From: [REDACTED]
Sent: 14 December 2020 10:43
To: Amber Willard
Subject: RE: P/108/20/HH
Attachments: P0010 - Section.pdf

P/108/20/HH

Rev	Revision		Date
PROJECT			
32 East Front Road, Pagham			
TITLE			
Proposed Floor Plans			
DRAWING No. P0002		SCALE (@A1) 1 : 50	Project Ref: J20025

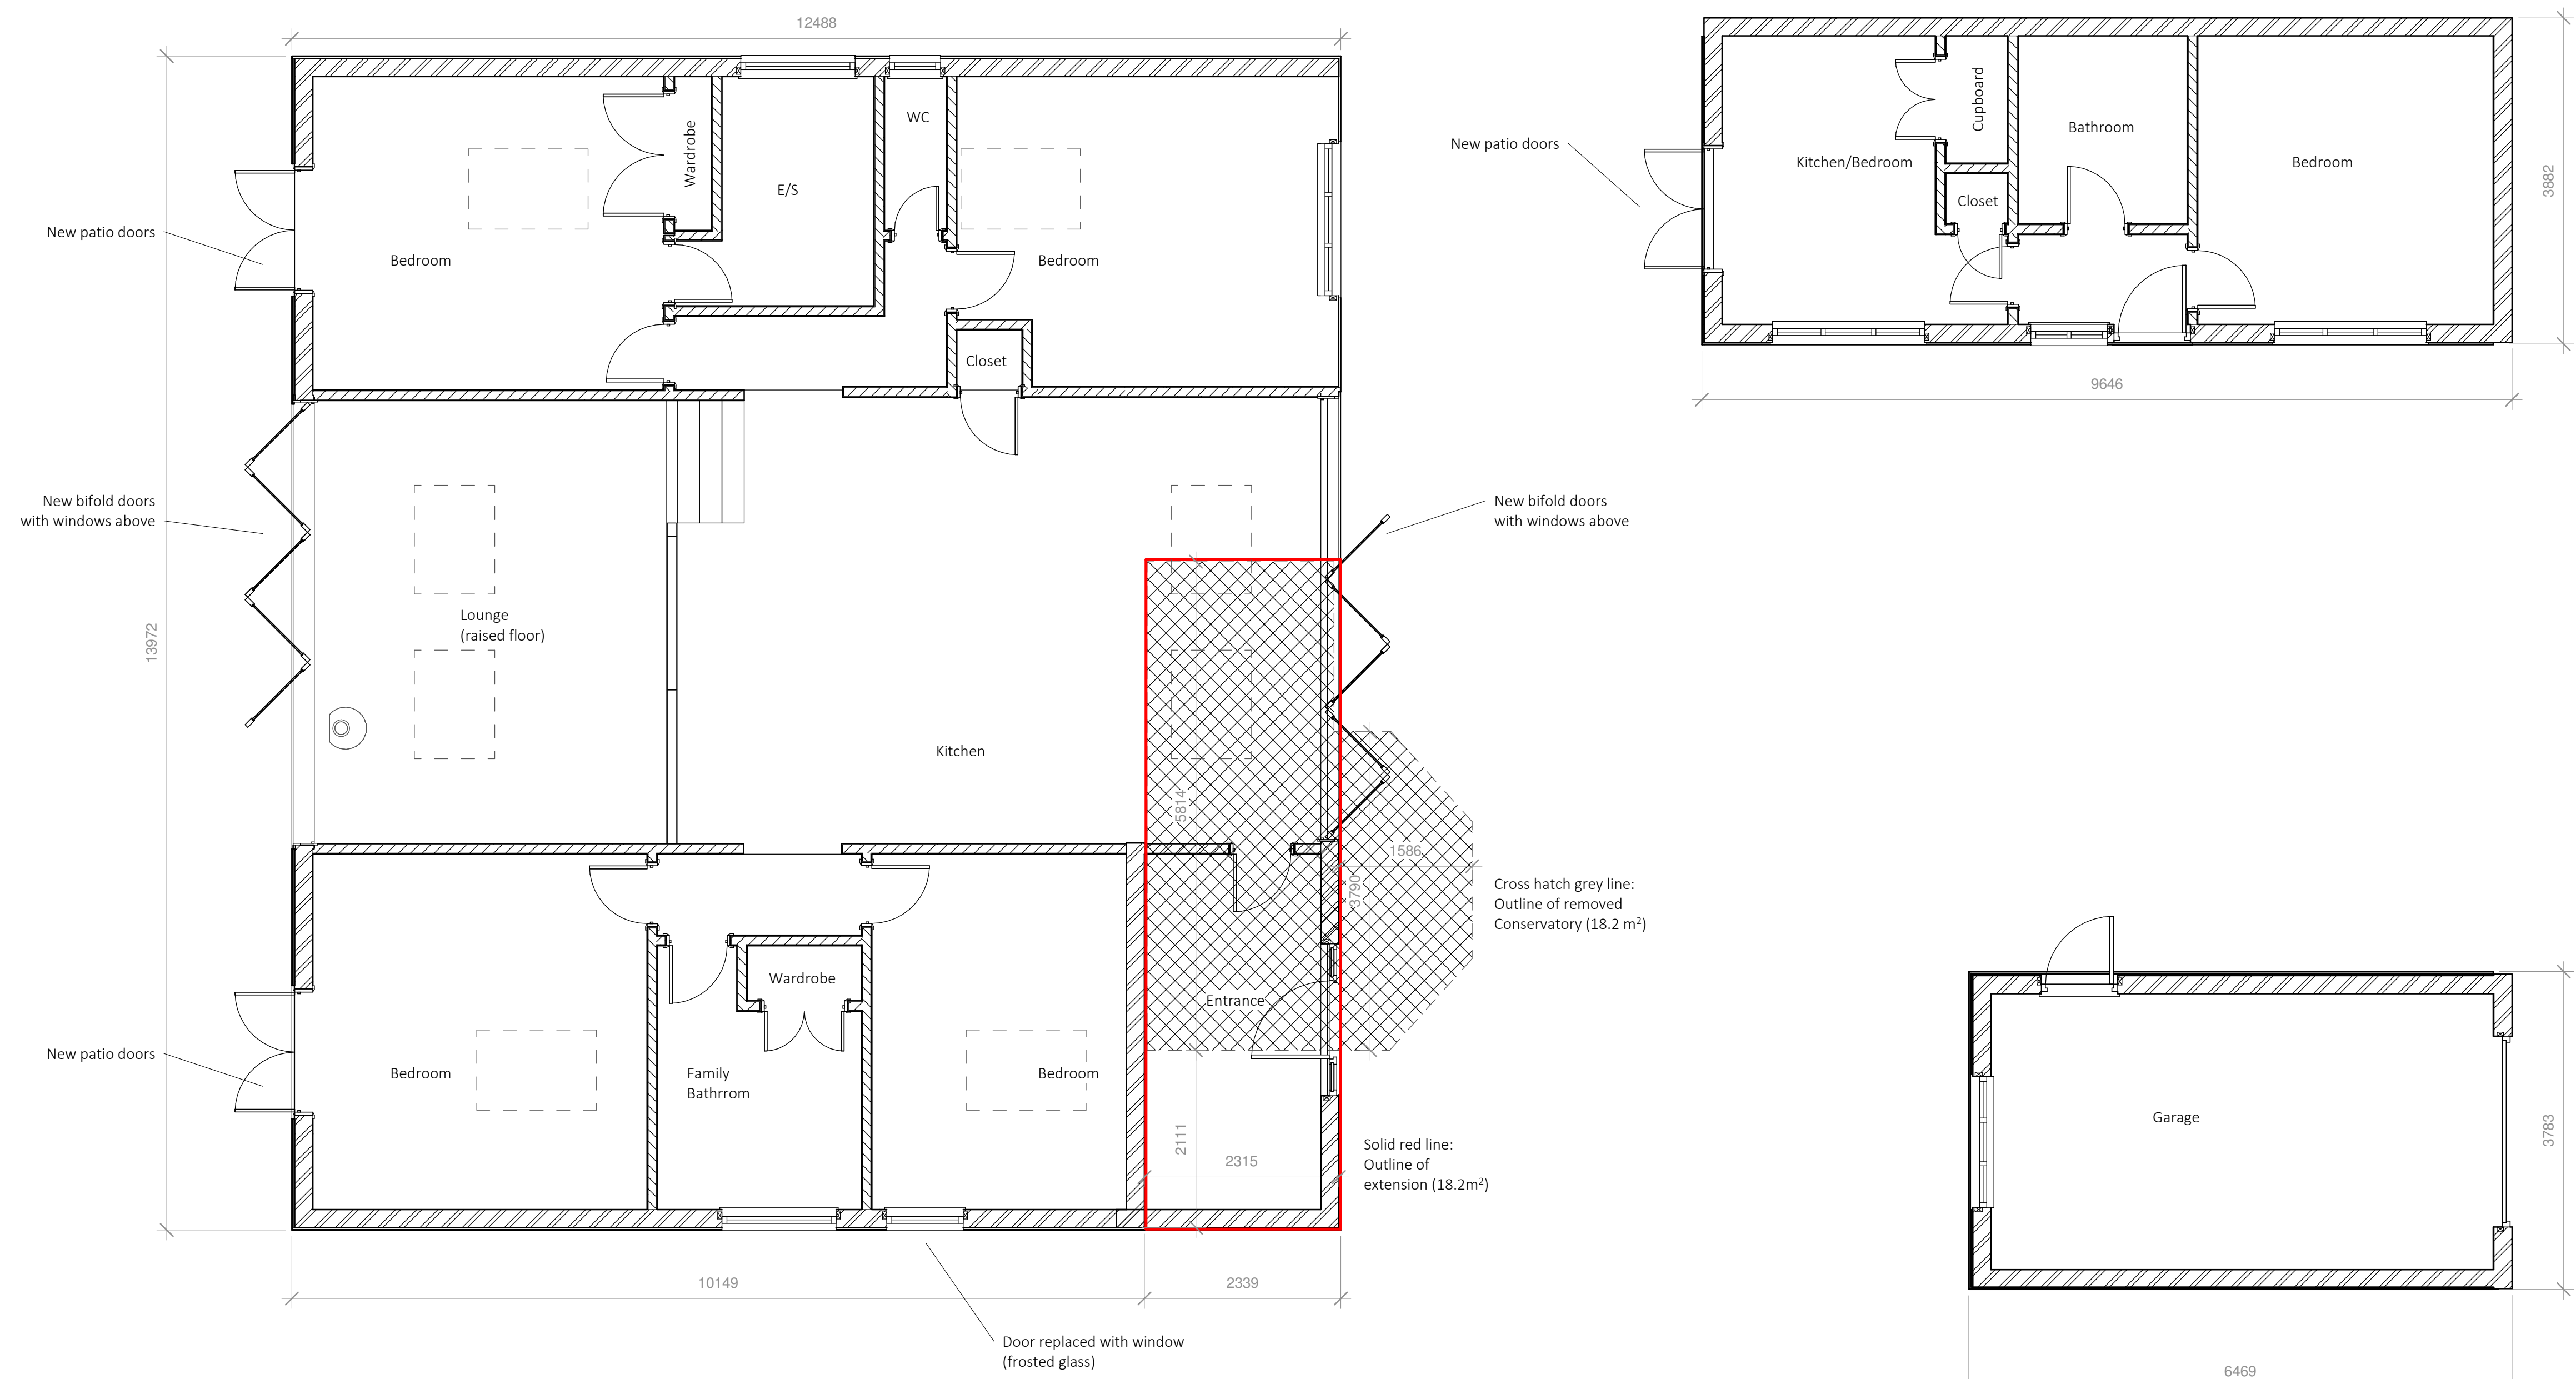
I note it states the rear living room area floor level will be raised, so the doors open out onto the decking. Can you advise how high the decking will be off the floor as it is hard to tell from the plans.

The beach is about 1m above the current external level (about 775mm above the current floor level). We propose to bring the internal floor level up to this height just in the lounge area by creating a raised platform internally with some steps up internally. The decking will be fixed to the house, and the wall. It will then oversail the beach, basically cantilevered at beach level, all within the red line as defined on the title deeds.

Rev	Revision	Date
PROJECT		
32 East Front Road, Pagham		
TITLE		
Elevations - Proposed		
DRAWING No.	SCALE (@A1)	Project Ref:
P0006	1 : 100	J20025
THE EMARRA COMPANY		
www.emarra.co.uk Tel: 07803 924465 Email: info@emarra.co.uk

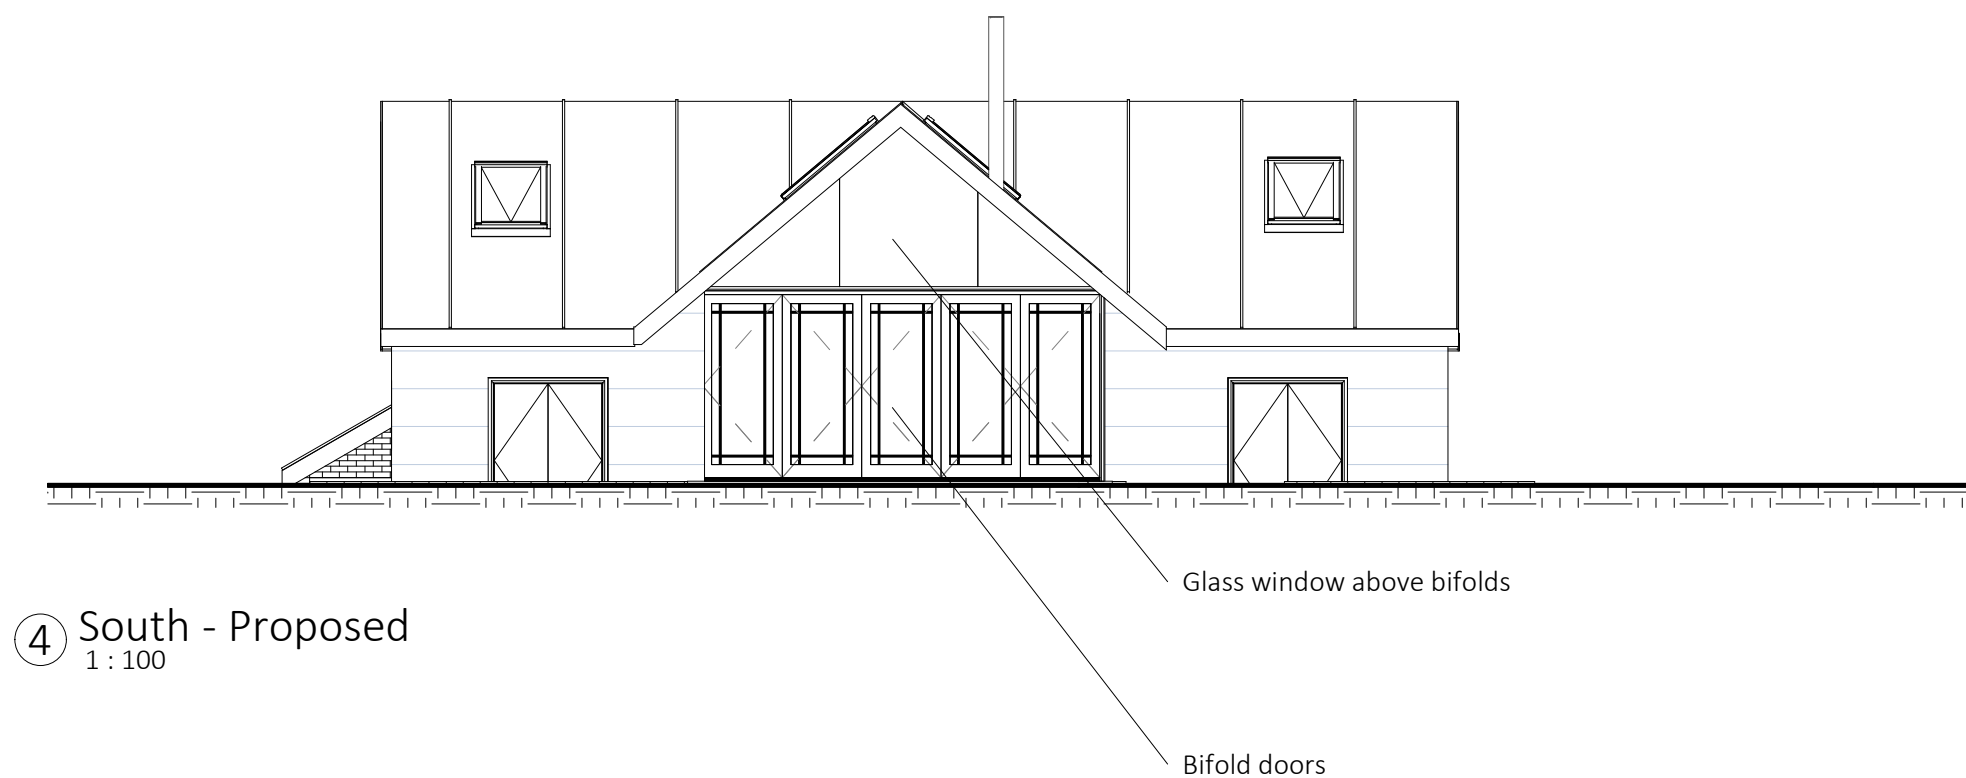
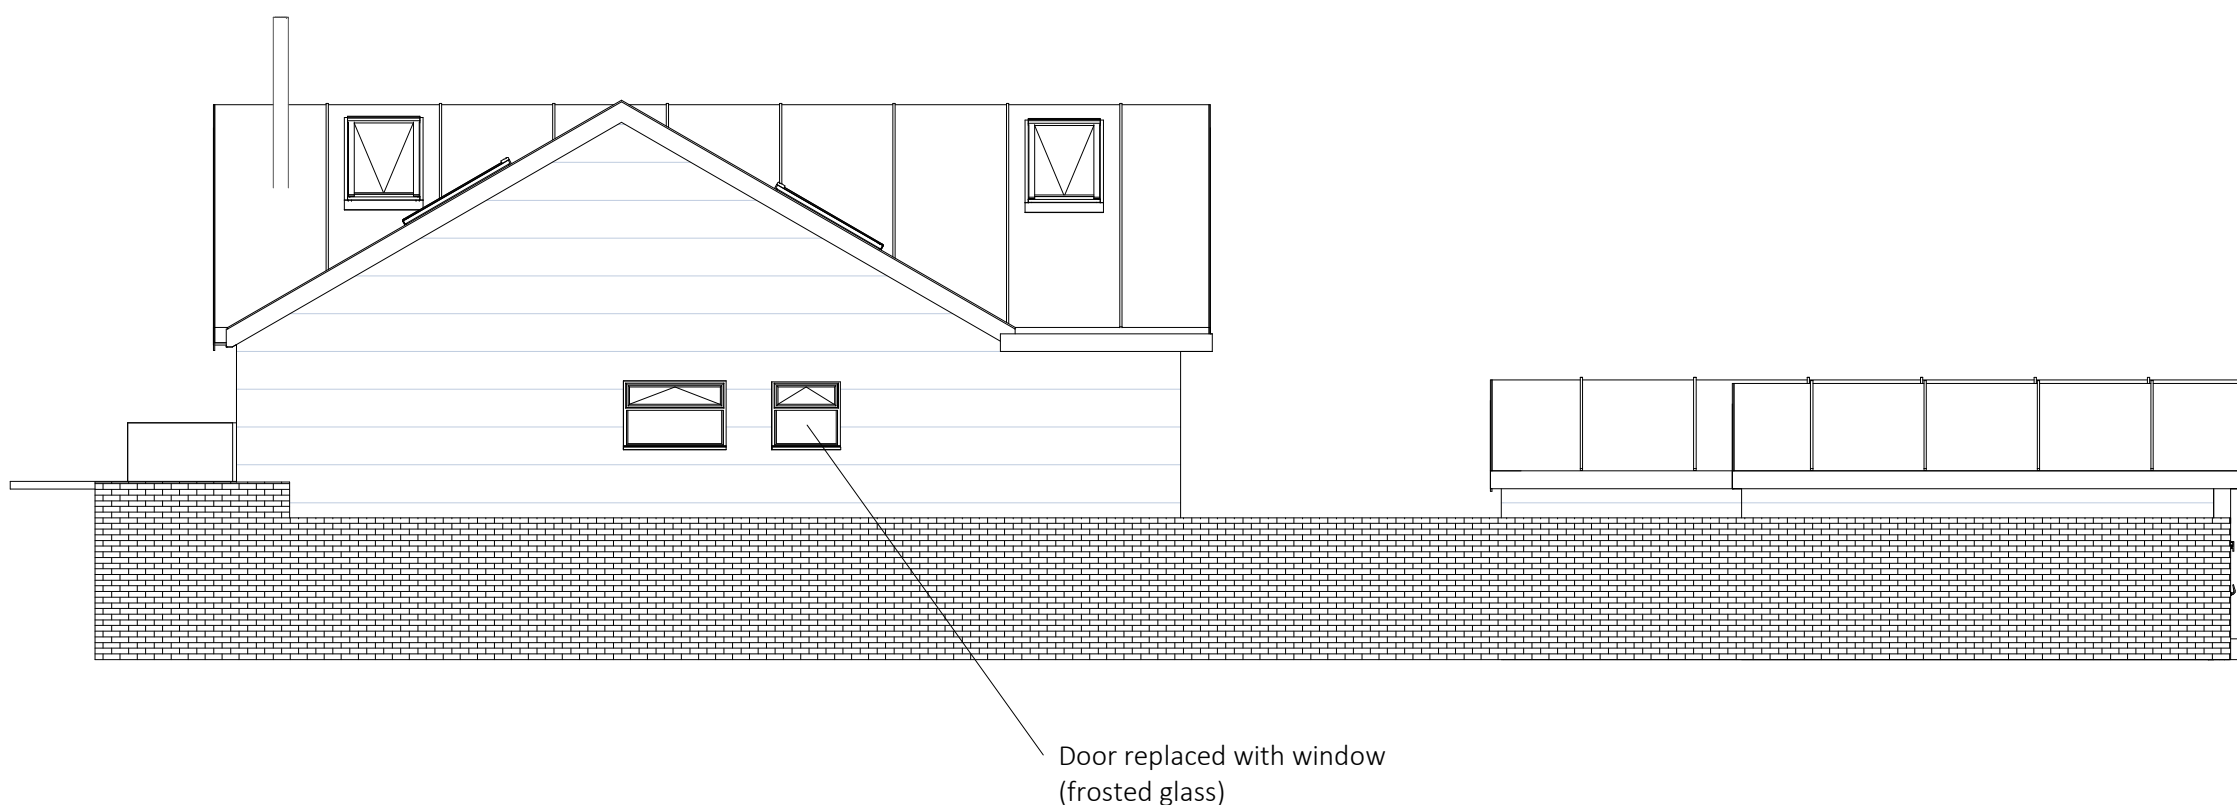
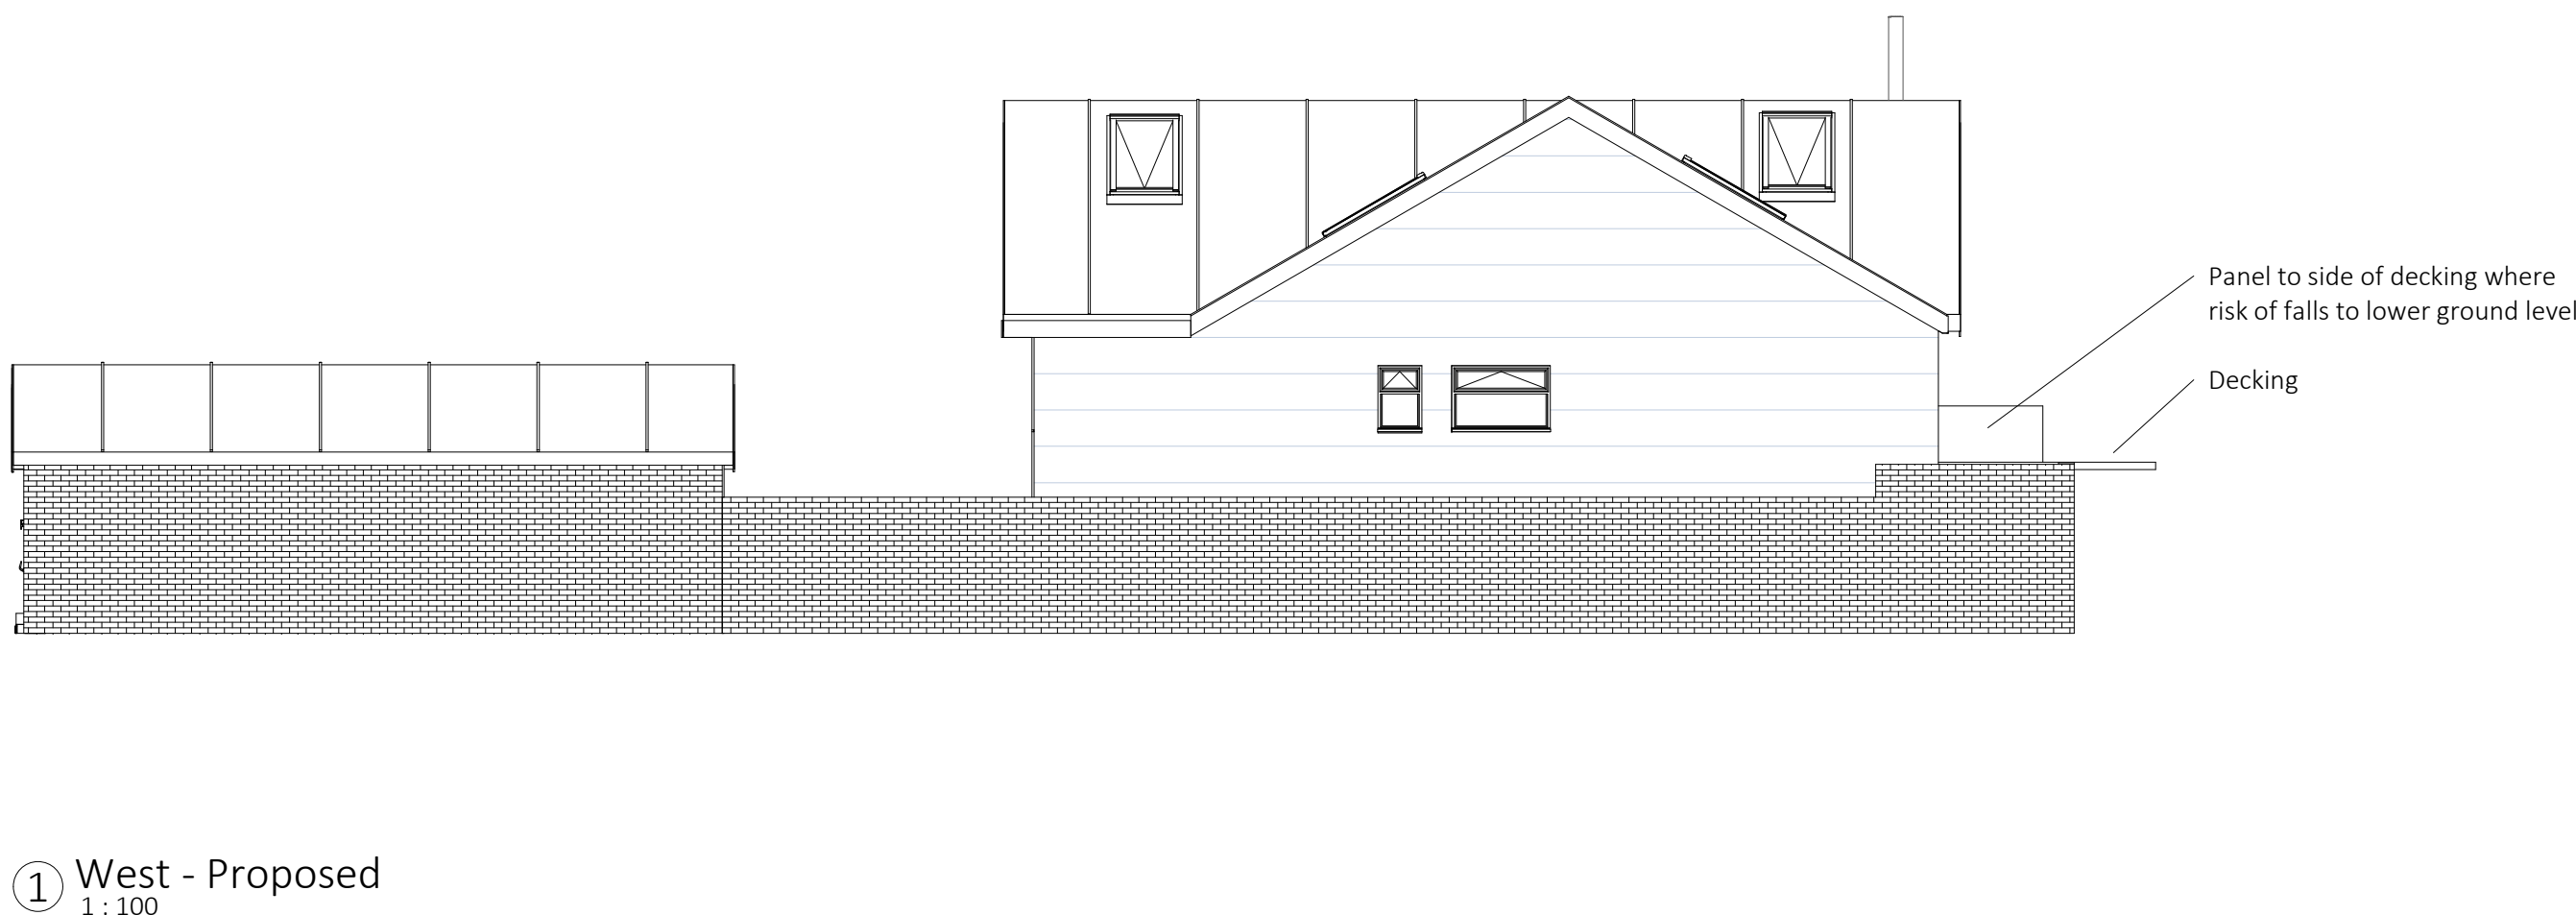
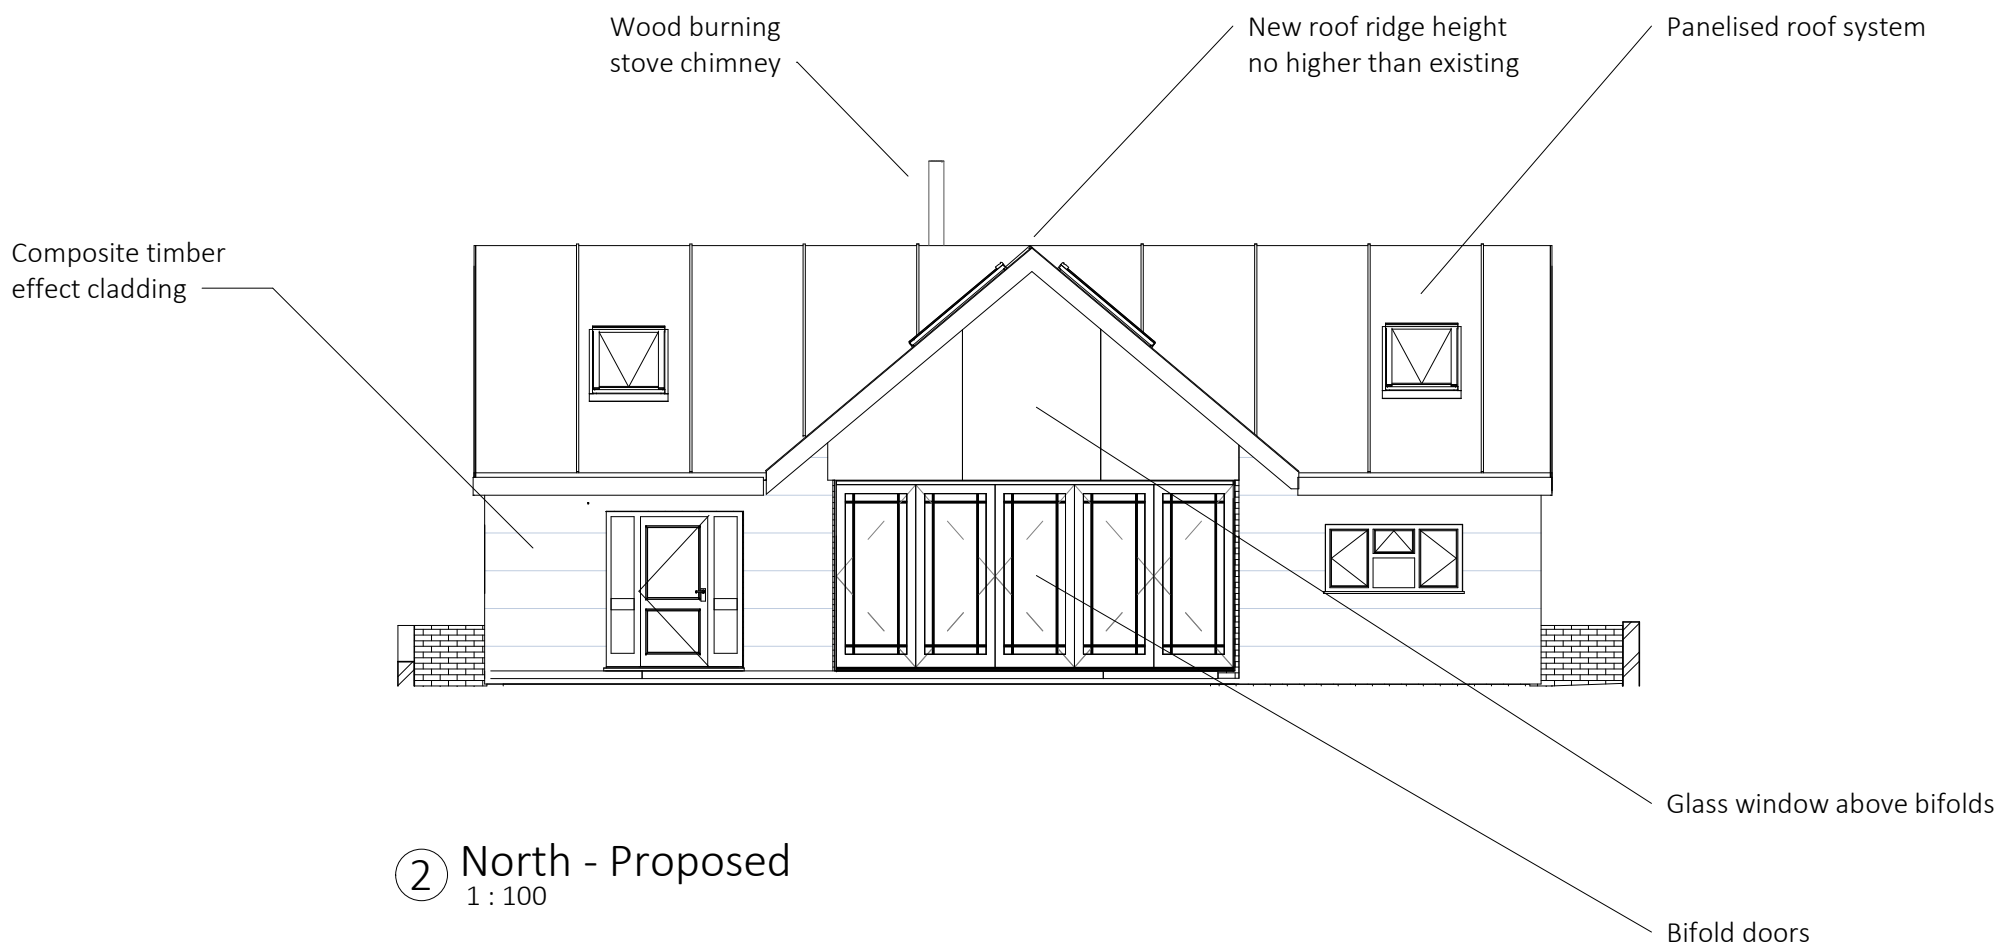
Also I see the decking has a balustrade to the side but not to rear. When you get the end of decking are there are stairs down or is it at beach level?

I'm am just trying to figure out whether the height will give rise to any views to the neighbouring sides and how this will look when viewed from the south.

It is at beach level. The side balustrades prevent falls to the lower path below either side of the decking. It is proposed that these are minimal e.g. glazed.

Because this is at beach level, it is no different to standing on the beach. It is not raised in any way. Below is an approximation of how it will look from the south:
